**ANGEL PLACE
LEVEL 8, 123 PITT STREET
SYDNEY NSW 2000**

RESPONSE TO SUBMISSIONS: SSD-21190804 - JALCO MANUFACTURING FACILITY

Table 1 Response to Submissions

Process Flow Diagram and Representation of equipment list issued for relocation

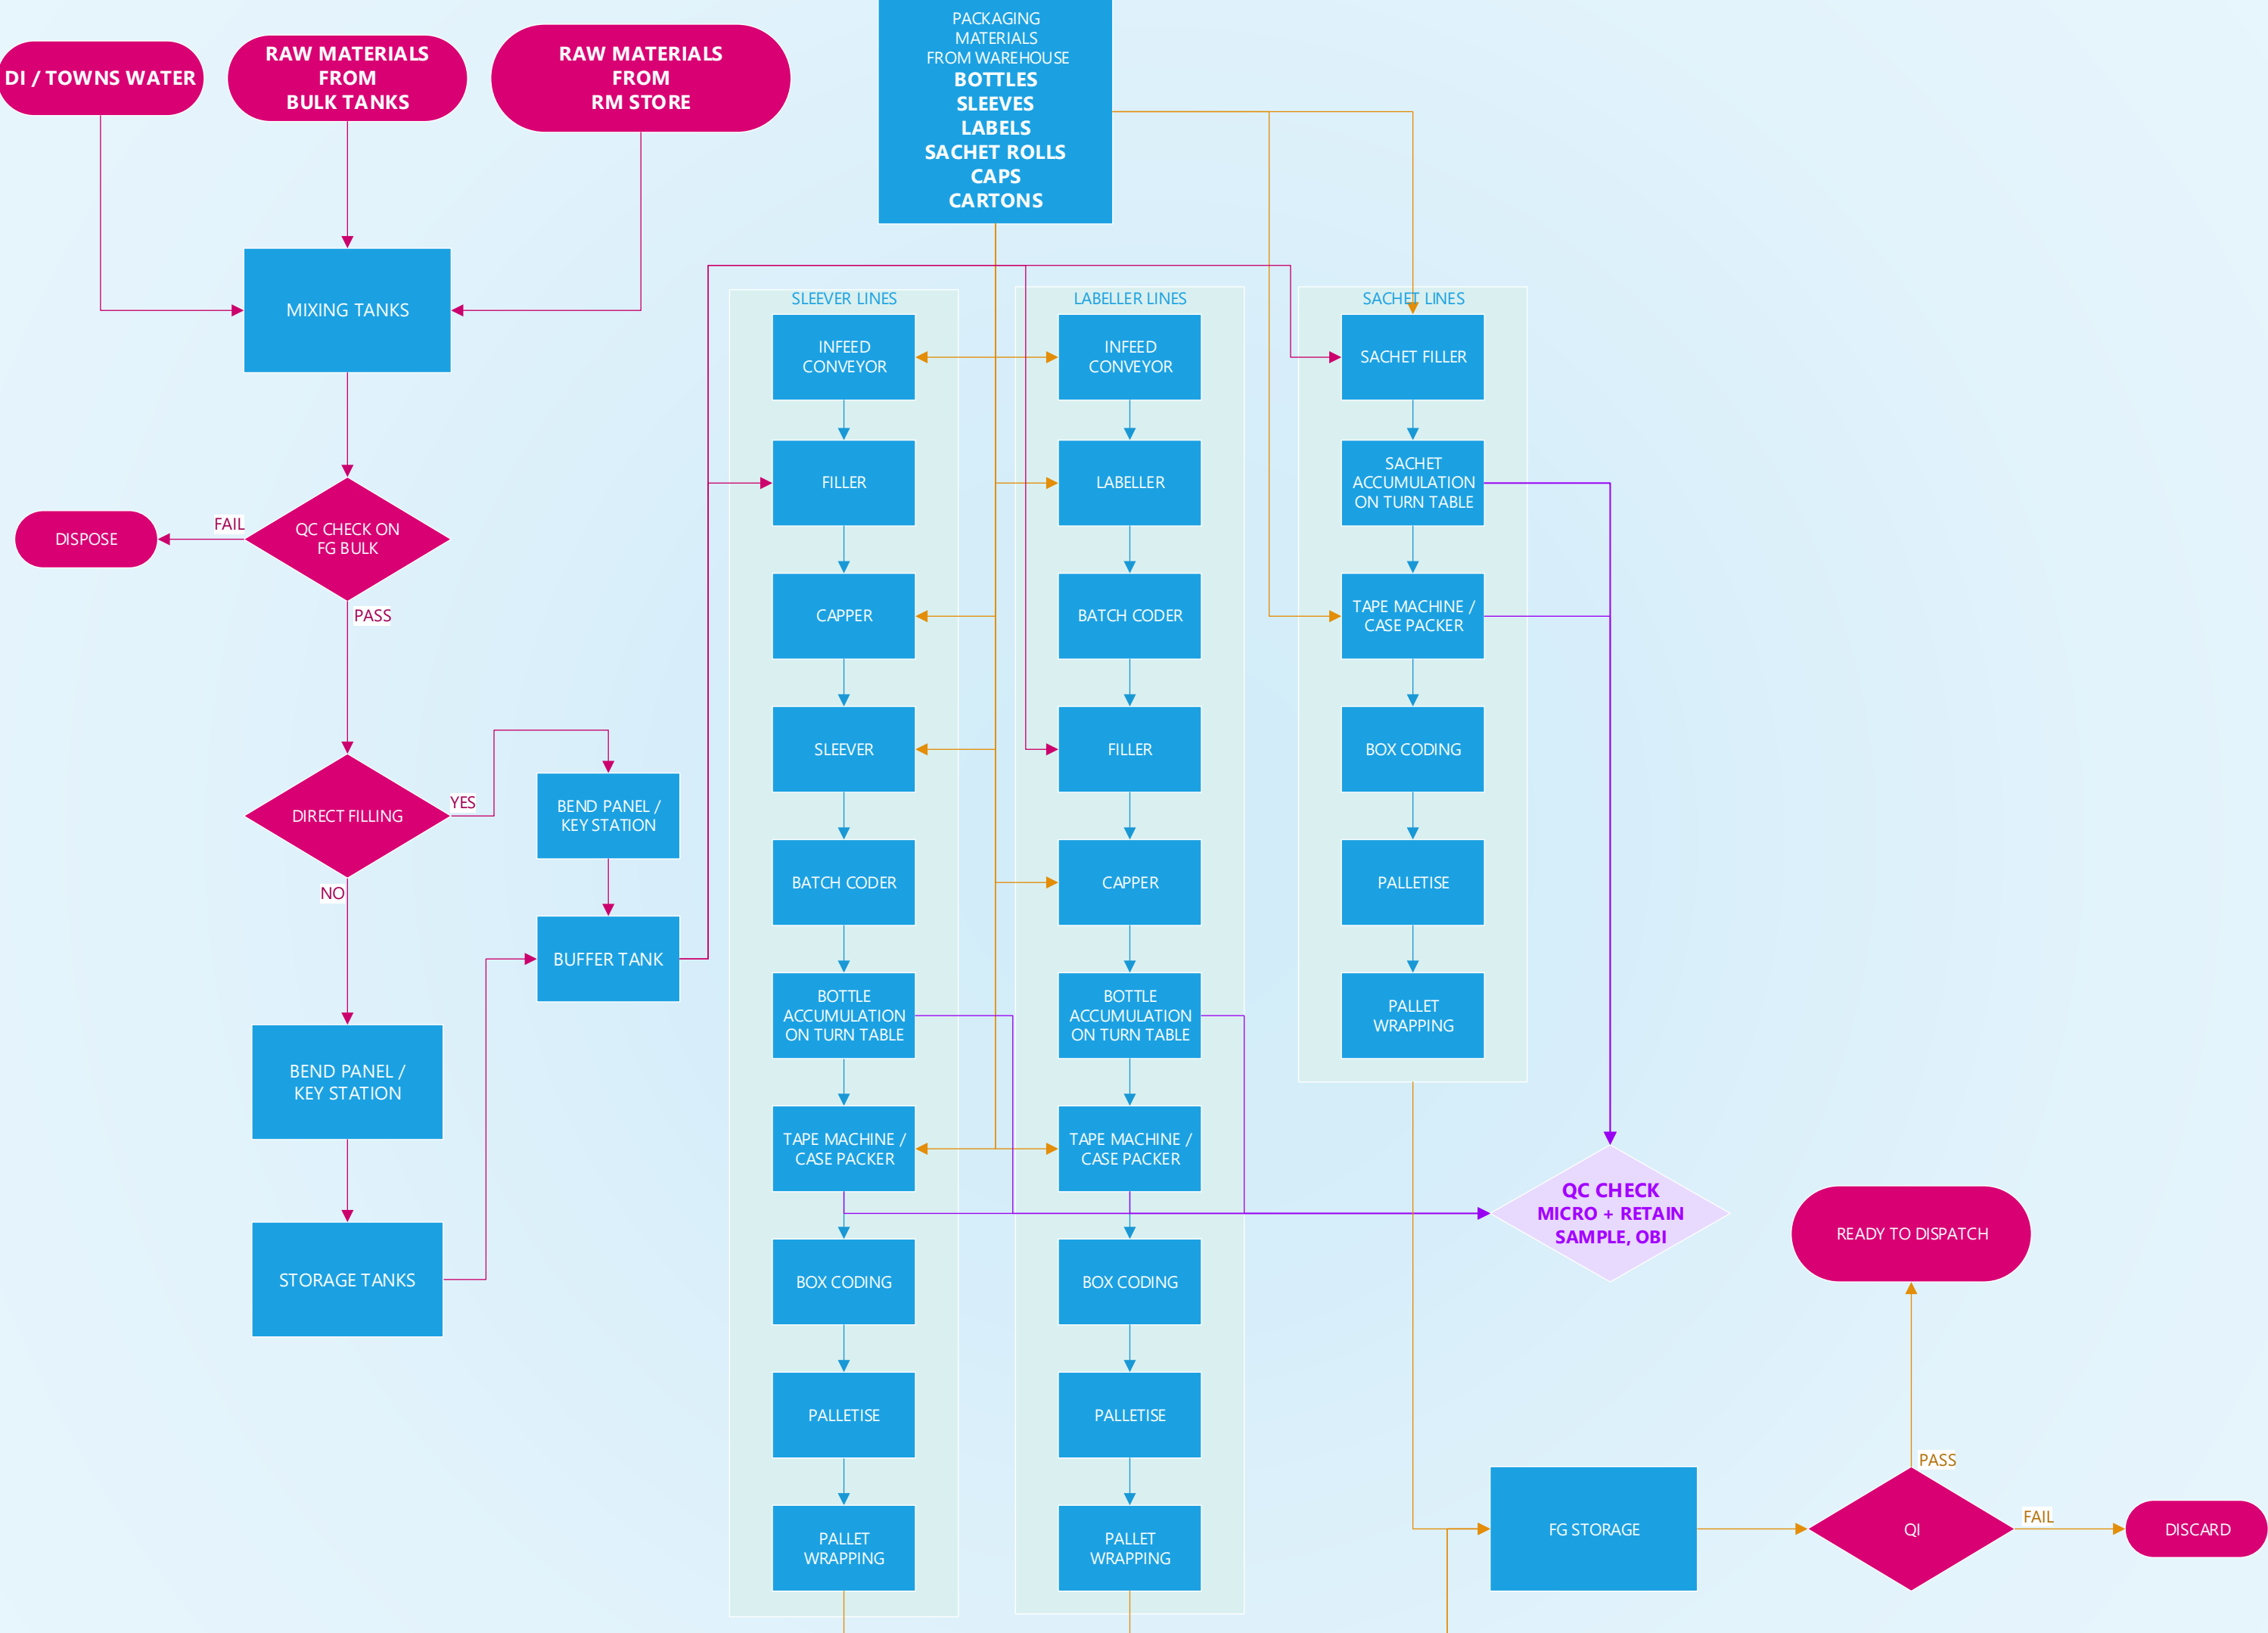
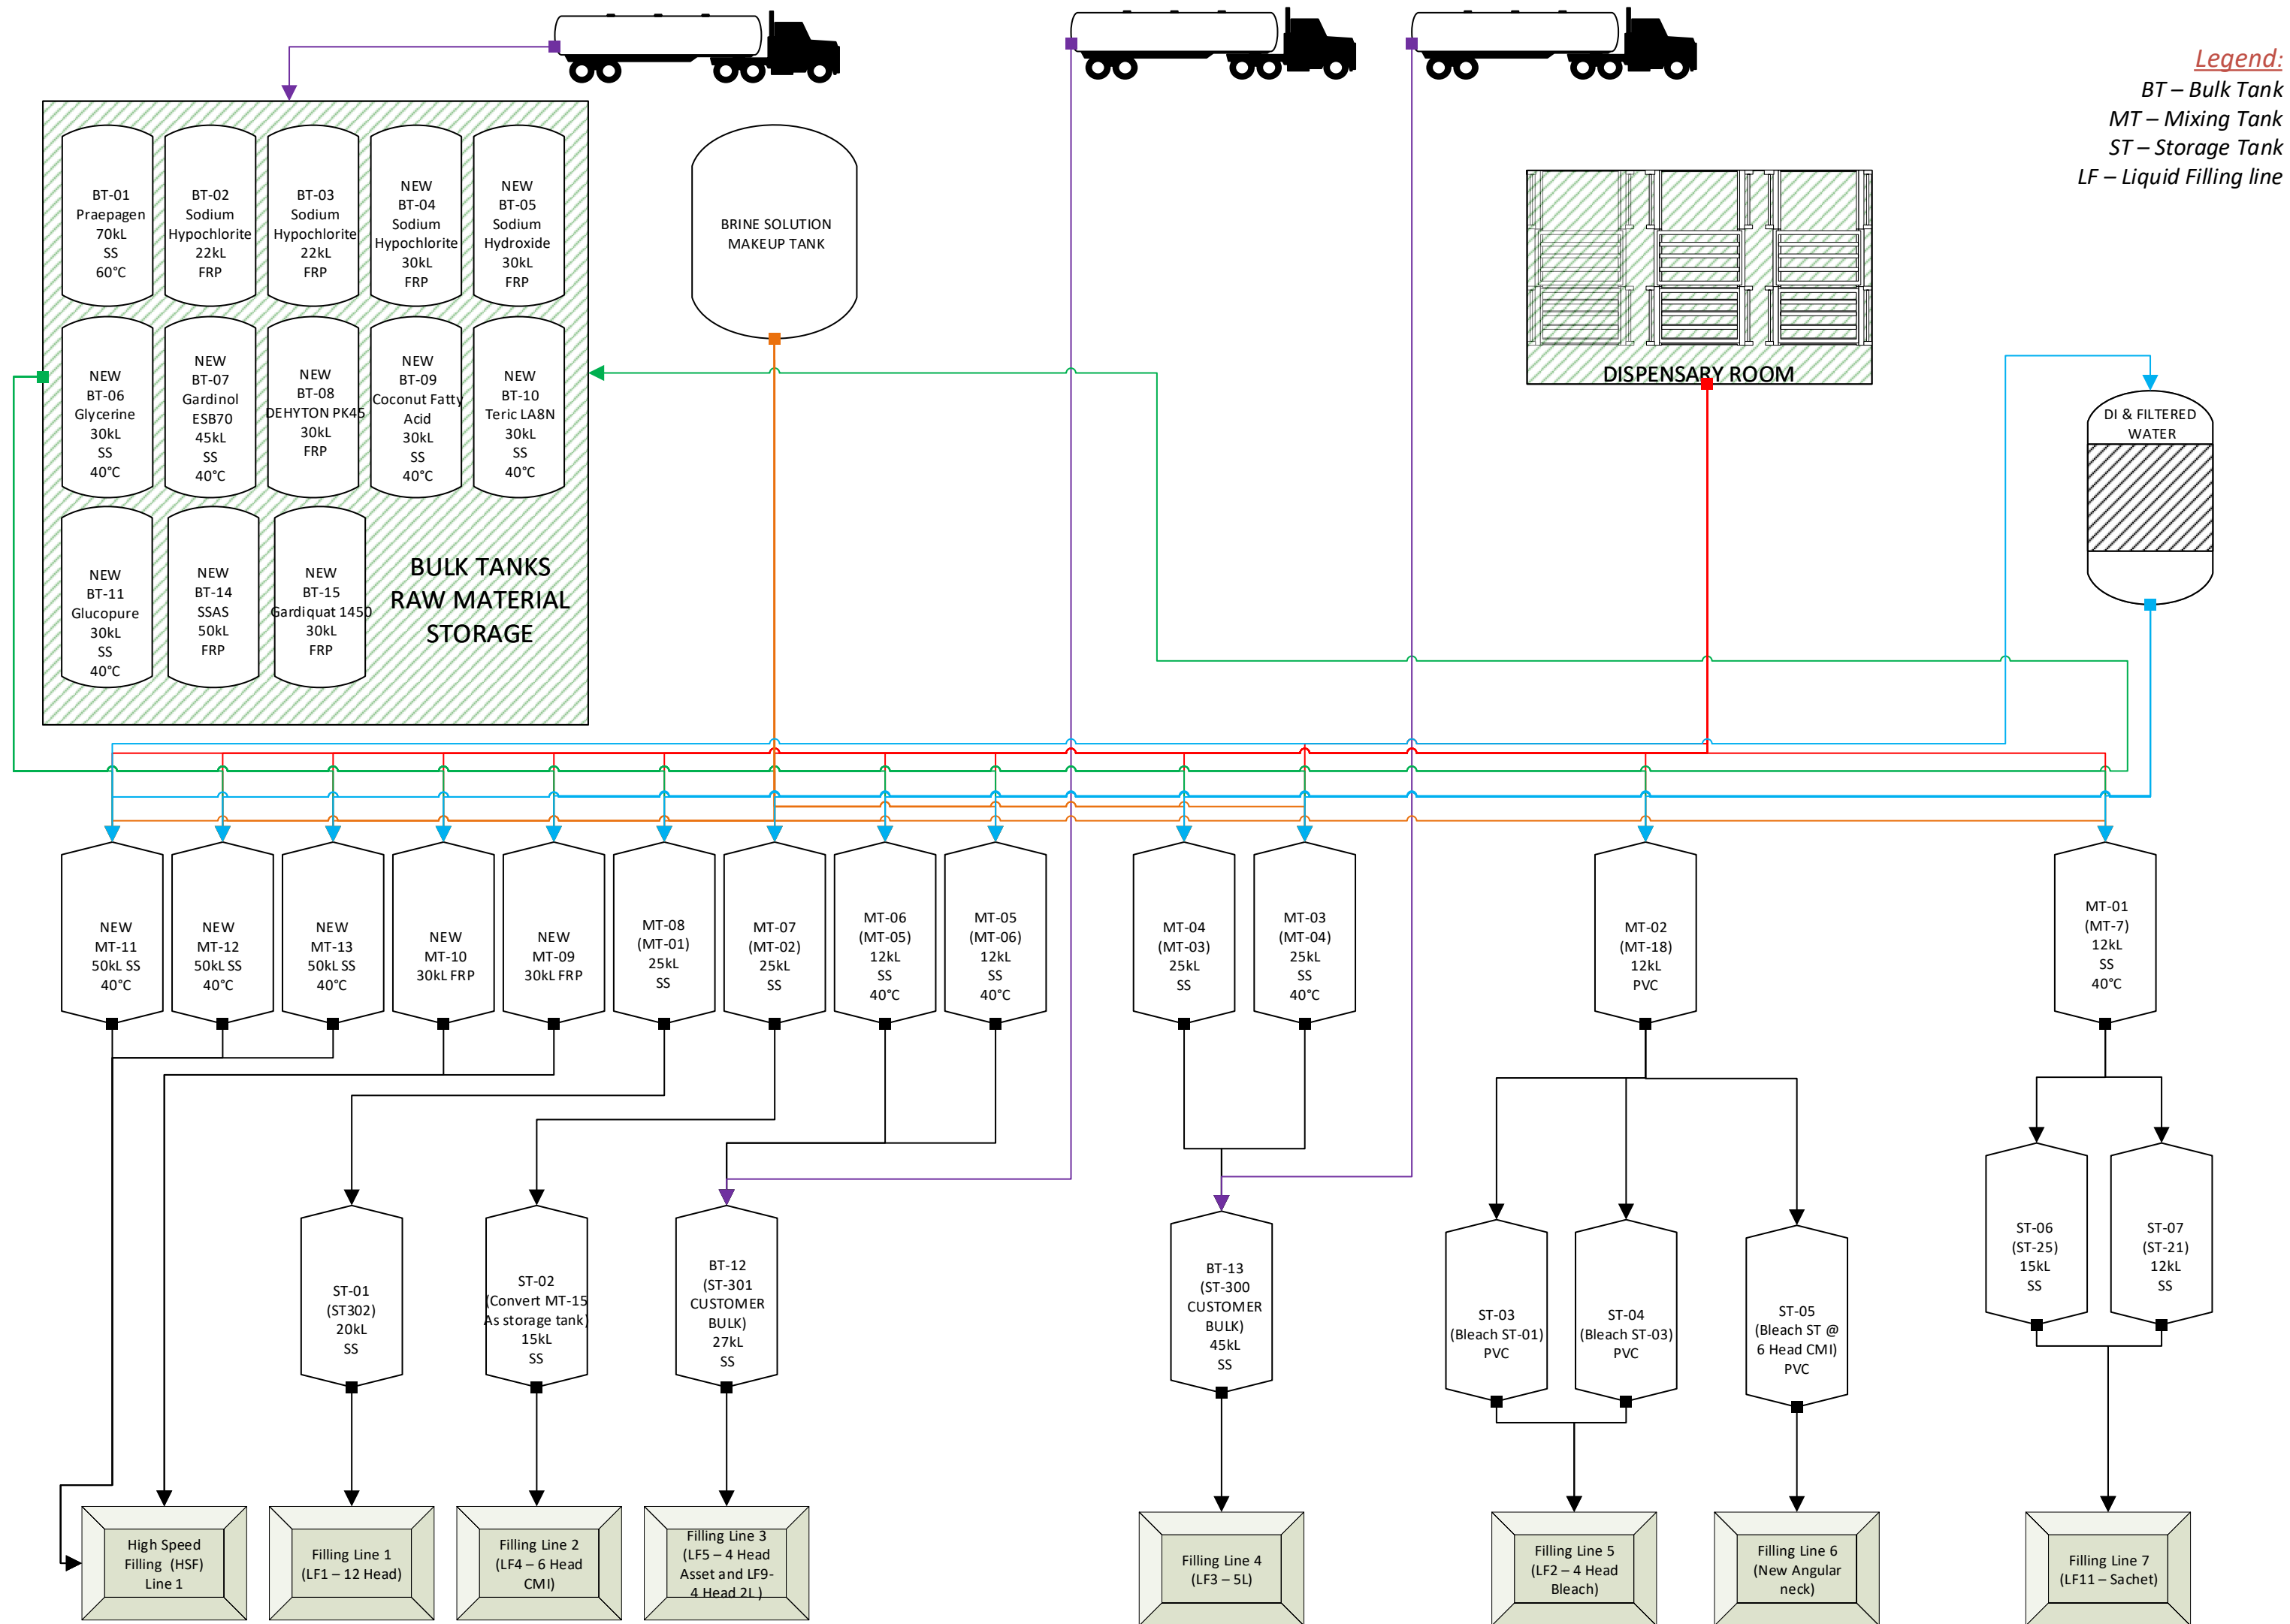
Matter for Consideration	Response
	These products are distributed to supermarkets and retailers across Australia. A breakdown of heavy vehicle movements is provided in Ason's Response to Submissions provided at Appendix B .
The Process Flow Diagram at Appendix S contradicts the information in the EIS relating to production capacity and employee numbers	The process flow diagram has been updated to reflect the production capacity and employment numbers for Jalco's site at Horsley Logistics Park and is now considered consistent with the information provided within the EIS. Refer to Appendix C .
The EIS suggests the site would have 60 staff and have a production rate of 4000 tonnes per year. Please clarify this contradiction.	The staffing reduction is realised through automation and machinery, where possible and viable. The staff breakdown per each phase is as follows: ▪ Phase 1: 60 Staff; ▪ Phase 2: 87 Staff; and ▪ Phase 3: 114 Staff.
